DECISION DELEGATED TO HEAD OF PLANNING

Application No: H09-0705-25 **Applicant:** A Sukerno
Proposal: Proposed Residential Development of 9 Dwellings
Location: Hooks Of Holbeach Land Adj. & Including 45 Fleet Street Holbeach
Terminal Date: 14th November 2025

5:00PM

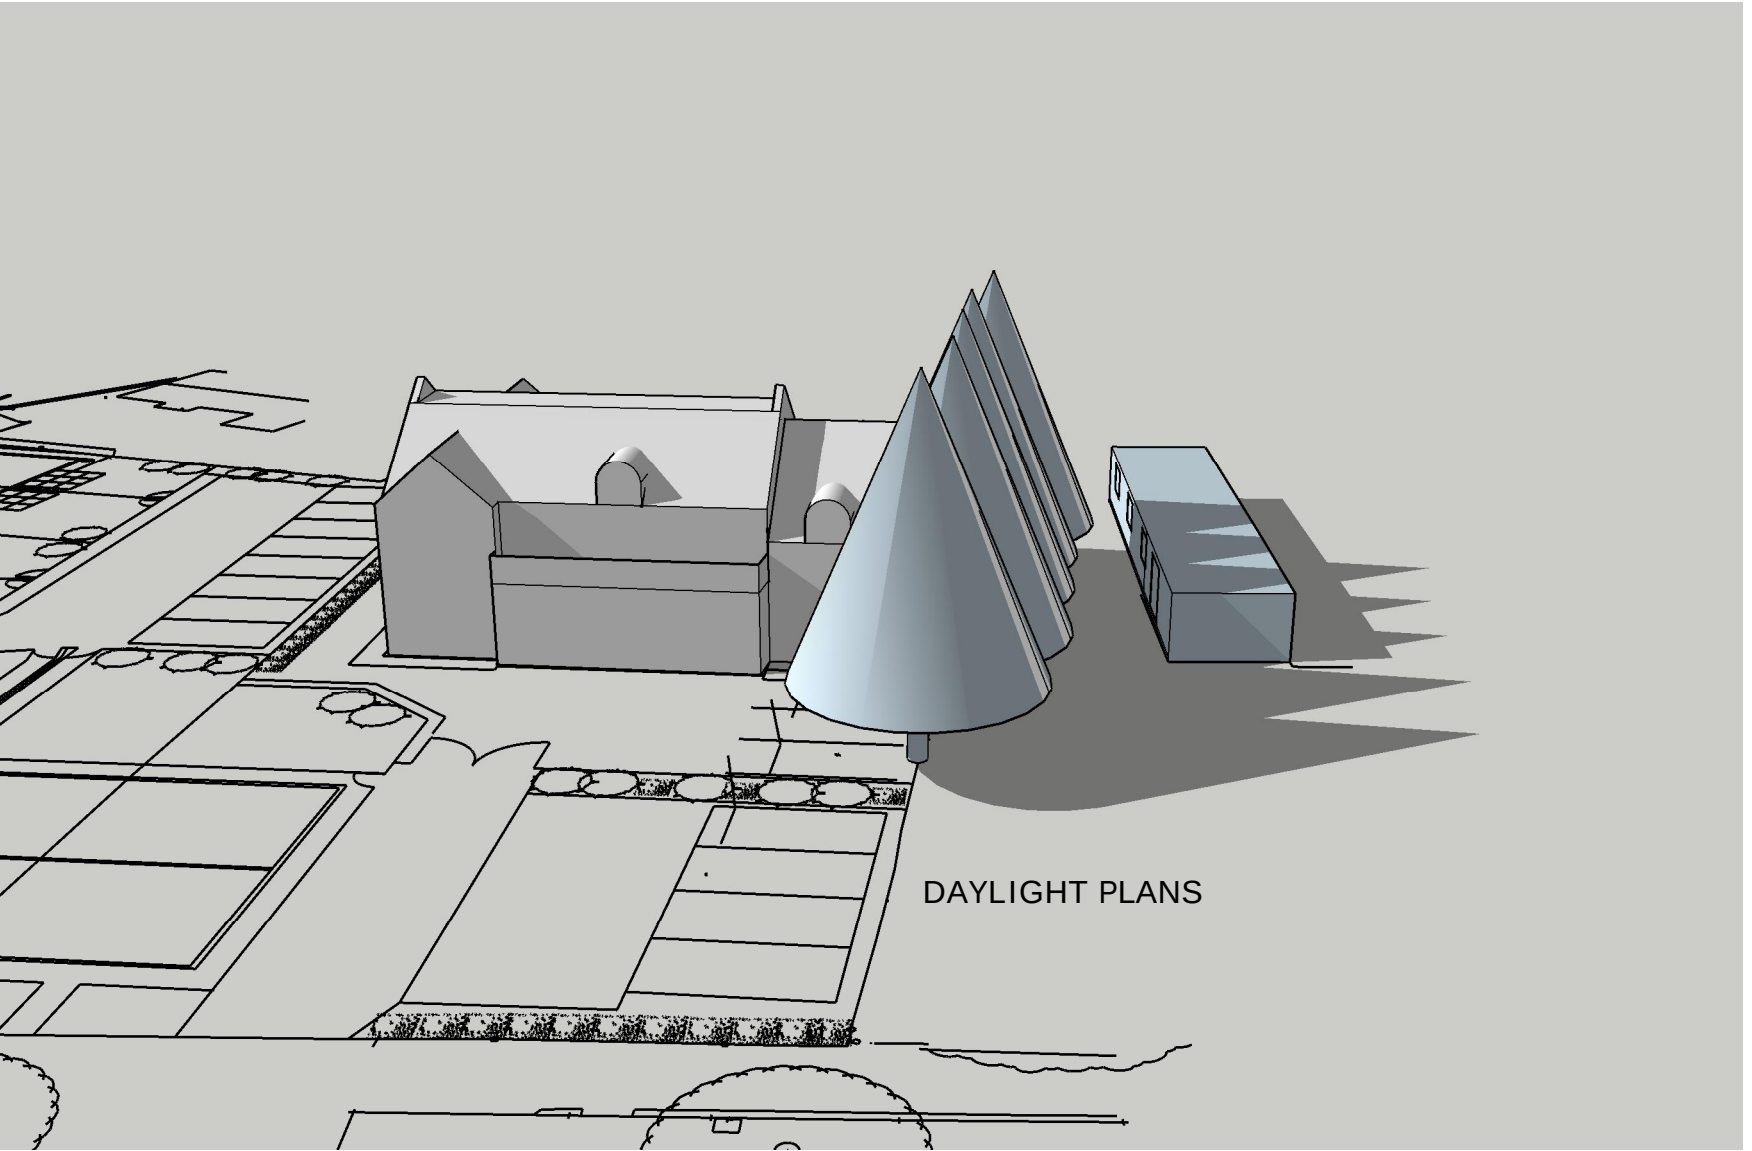
2. Amenity and Privacy The layout raises concerns about the amenity of future occupiers: The 6.8m separation between Plots 5/6 and Plot 4 is inadequate and would result in loss of privacy to Plot 4's garden. Plot 9's front balcony, although offset, would still allow direct views into Plot 8's rear amenity space, with only 10-11m separation between habitable rooms- below acceptable standards. The overshadowing assessment is limited, only considering one time of year and failing to assess impacts on all sides, particularly the garden east of Plot 9.

A daylight assessment has been provided as part of this proposal. This shows that the western elevation of the adjacent care home is already in shadow due to the existing trees. The proposal would not exacerbate the level of shadow cast. In stepping the roof towards this boundary downwards, there would be a reduced level of shadow cast in any event. The rear windows of Plot 9 would create some level of overlooking towards 1 Creewood Close, albeit this is not considered to be overly untoward.
